19/11/2021

**Sydney Olympic Park New High School (SSD-11802230)
Response to Submissions**

ATTACHMENT 1 – KEY ISSUES

SSDA
Site Plan Proposed

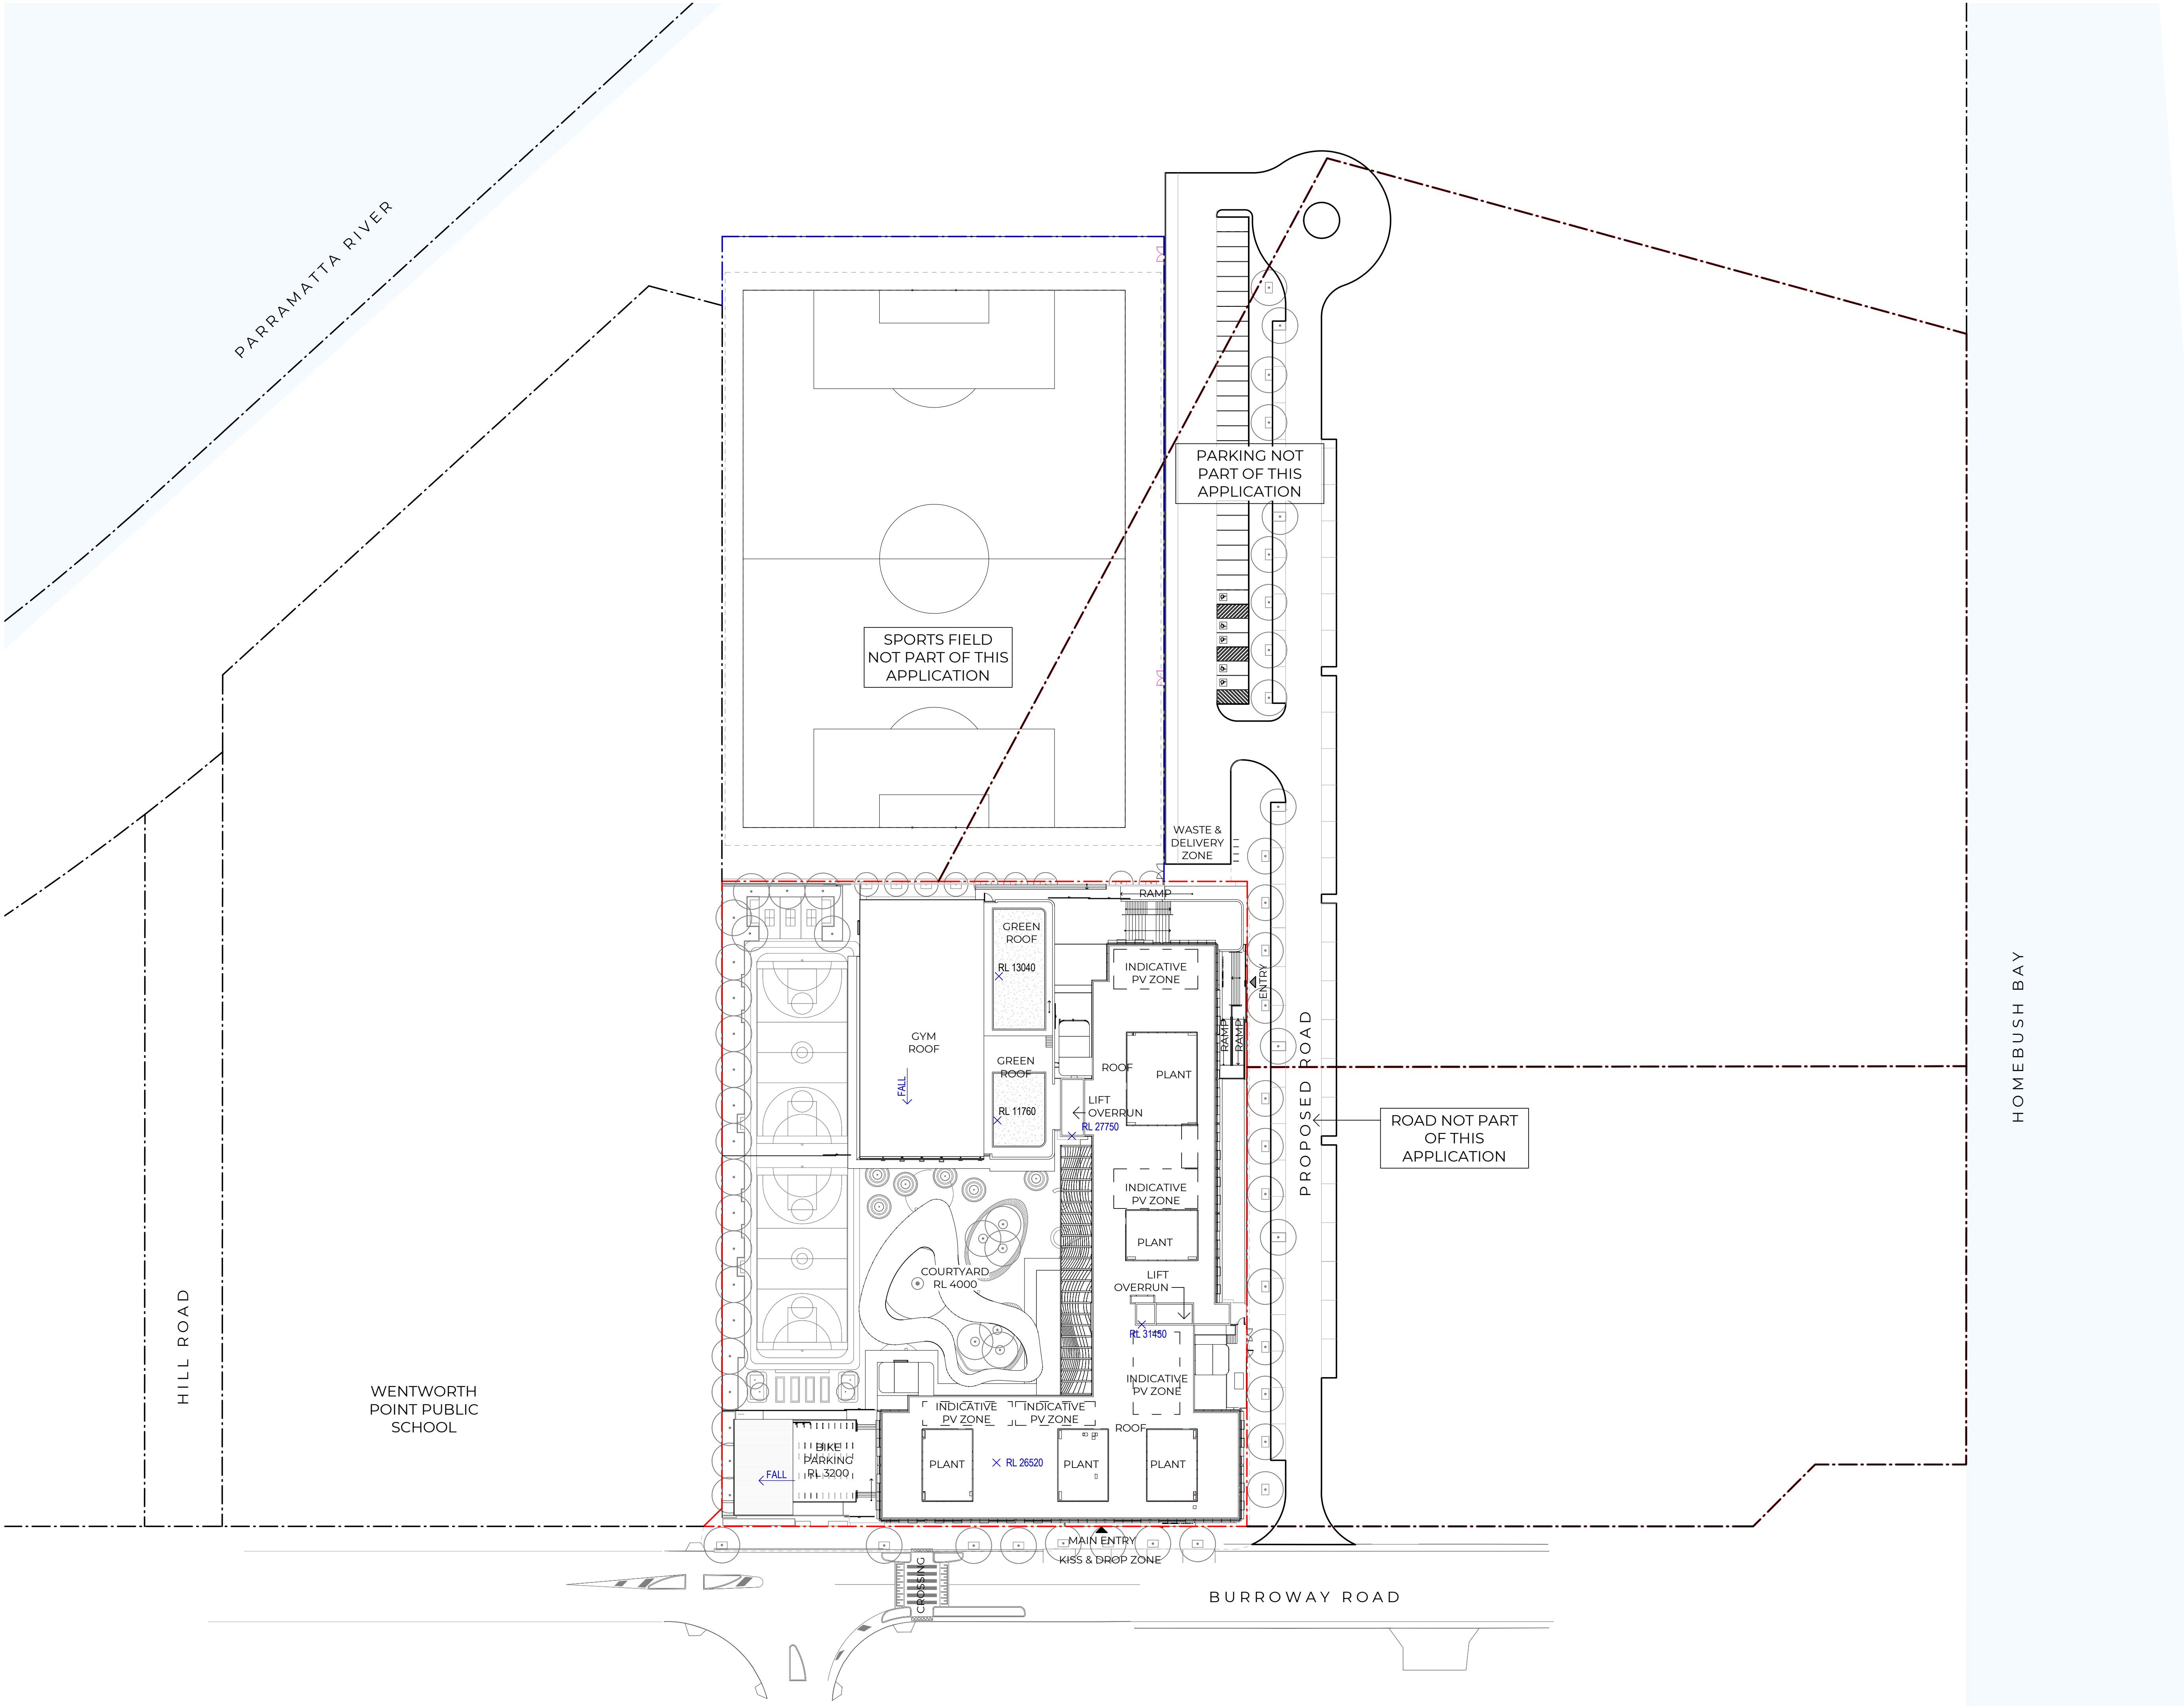
- Provide an assessment of the potential queuing impacts of the proposed drop-off/pick-up spaces on Burroway Road having regard to the existing roundabout and Wentworth Point Public School (WPPS). Mitigation measures must be proposed where required to address impacts.

- Demonstrate that the footpath width on Burroway Road adjacent to the roundabout and on site bicycle parking is sufficient to cater for the expected pedestrian demand and complies with relevant standards.

- opportunities to soften the boundary between WPPS and the subject site.
 - further scale details of the undercroft entry, providing wider footpaths on site frontage and demonstrating the key physical and visual connections throughout the site.
